**Consultation Response from KC,
Trees**

2026/91327 25, Barnsley Road, Flockton, Huddersfield, WF4 4DW

Erection of first floor front and side extensions, two storey rear extension, single storey rear extension, ancillary building and garages to front with glass link and associated external alterations

Date Responded: 08/09/2026

SITE LAYOUT - EXISTING

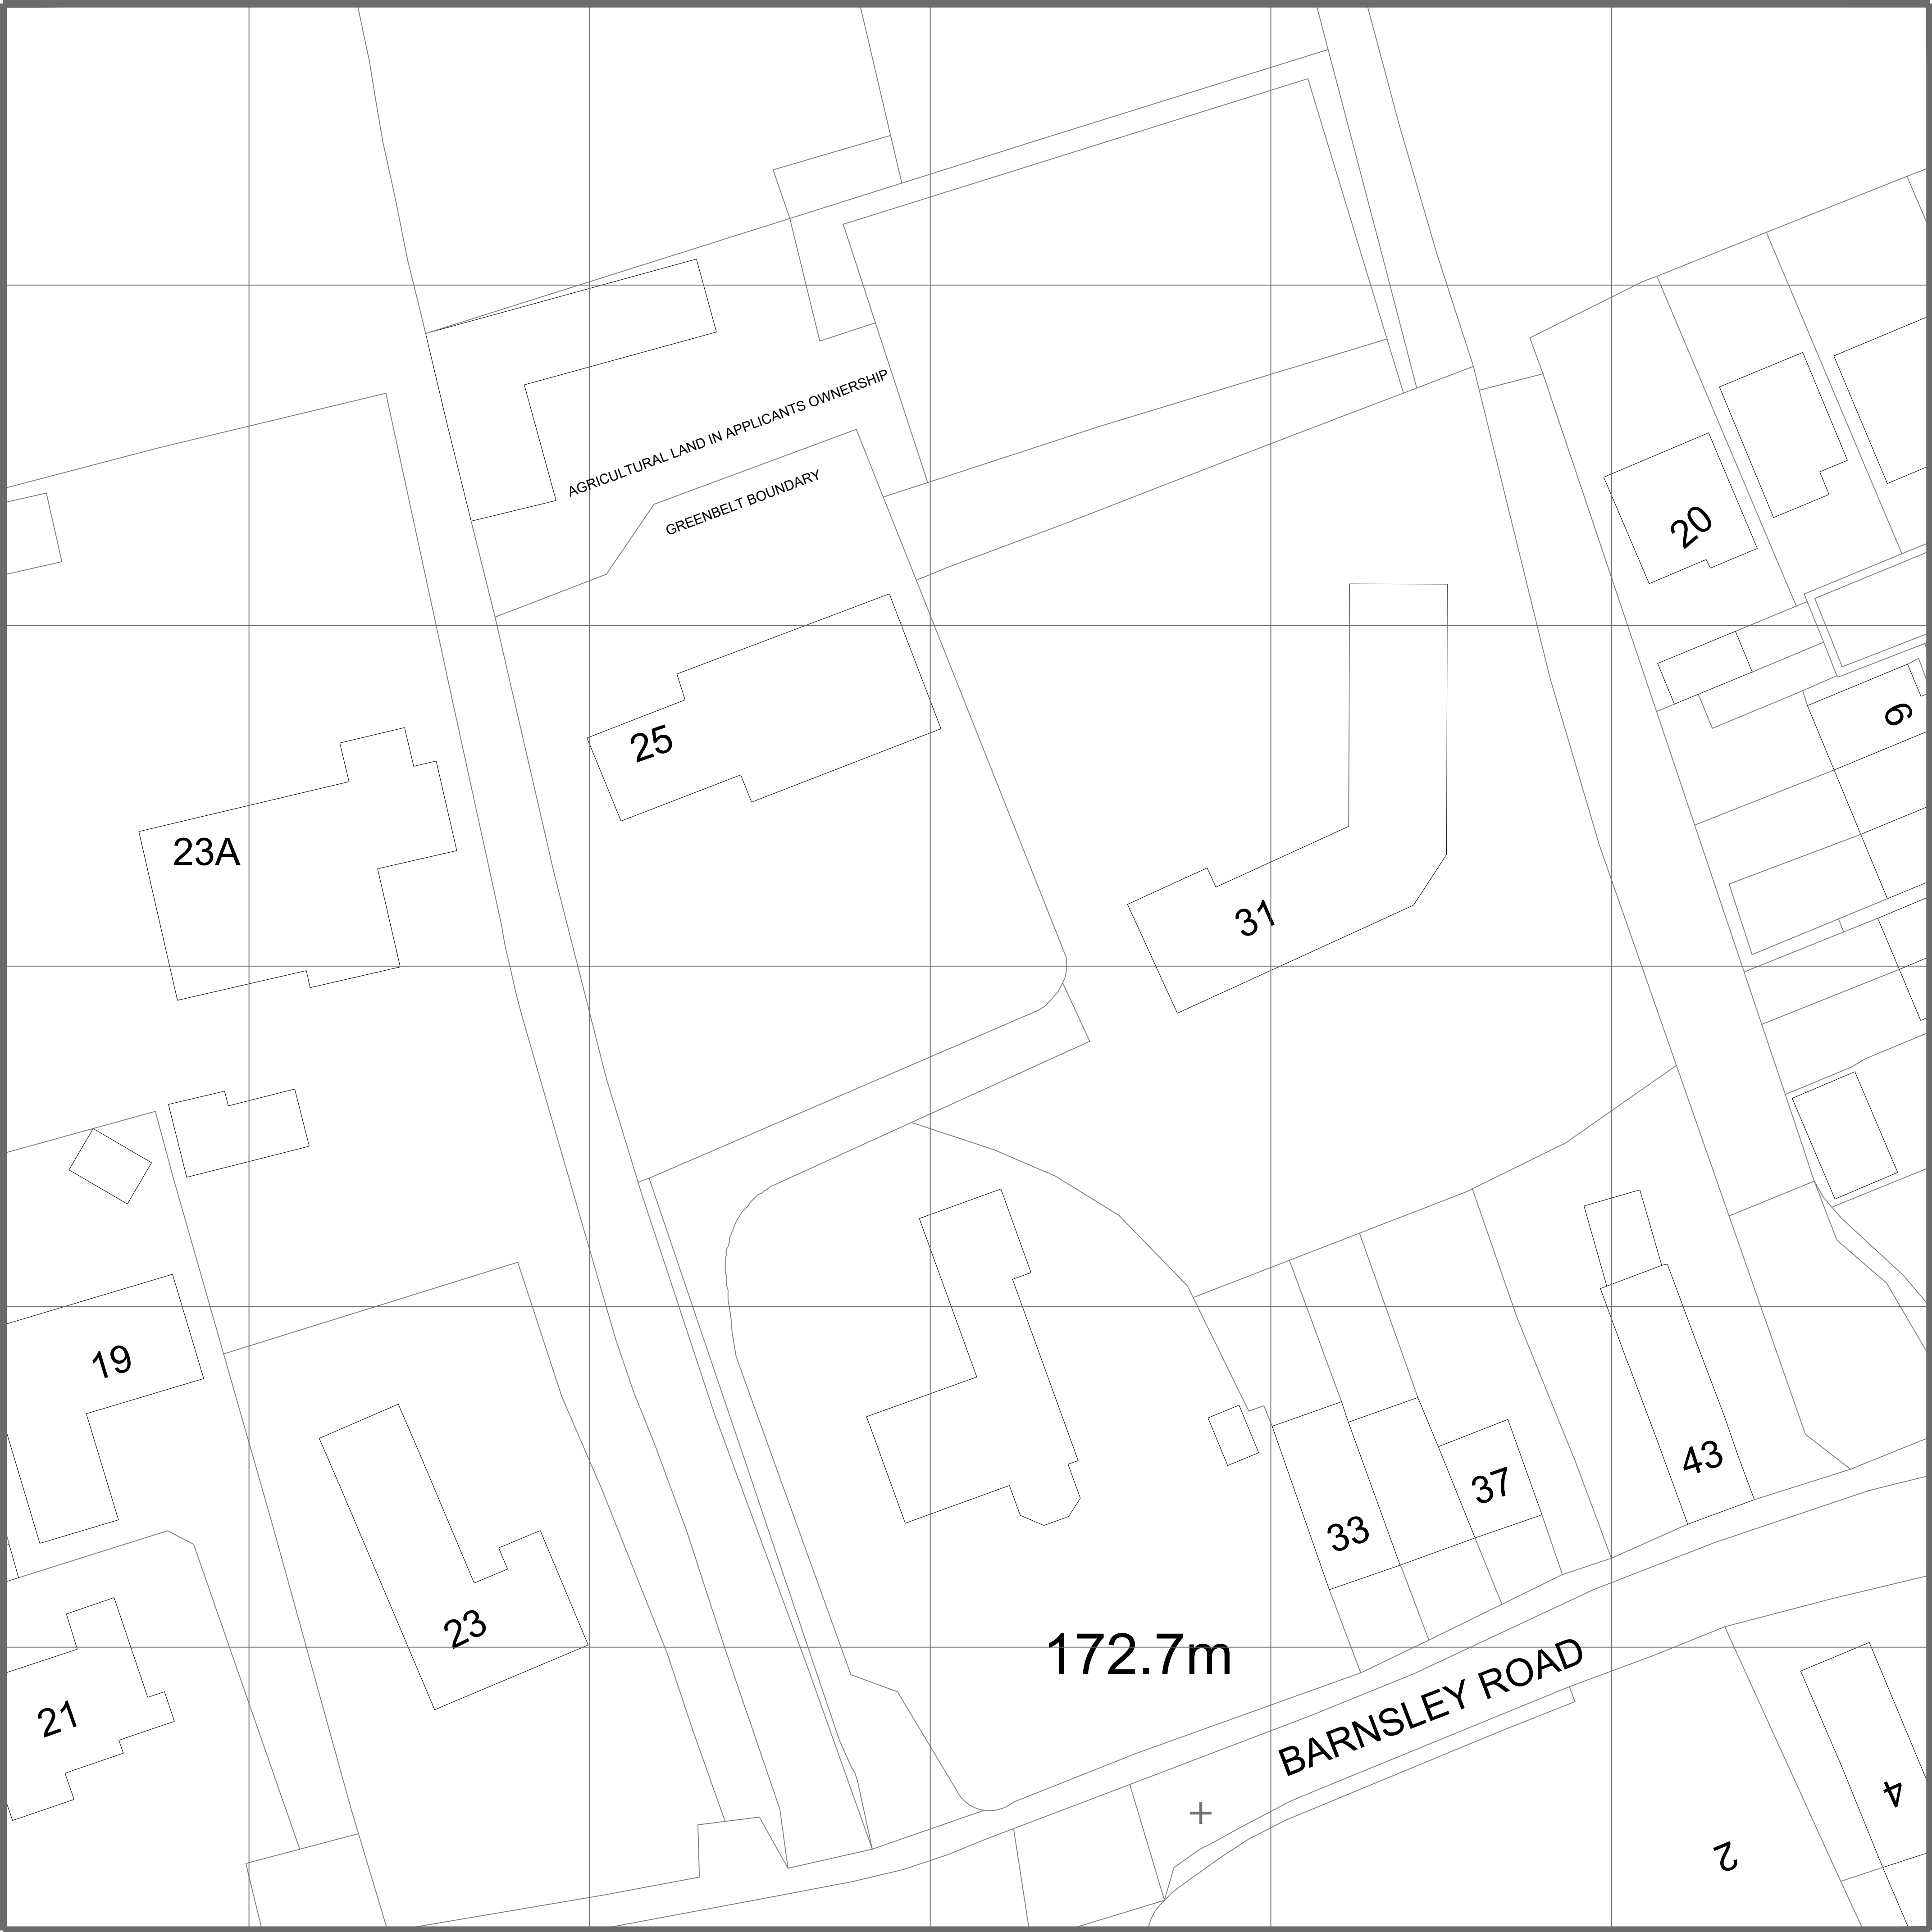
Whilst the proposals would significantly lessen the number of trees within the site all trees proposed for removal are low category trees which offer little amenity value to the wider area and landscape. They all show either defects or heavy past pruning which limits their future useful life expectancy.

Tress T10 and T11 are to be retained and the suggested protection is deemed adequate due to the existing hardstanding/driveway which will have limited root intrusion into this area. This also suggests that there is likely to be little to no roots present where the proposals foundation protrude into the calculated RPA.

On the whole KC trees has no objection to the proposals providing some mitigation planting is set under a landscape condition to be located somewhere within the wider site.
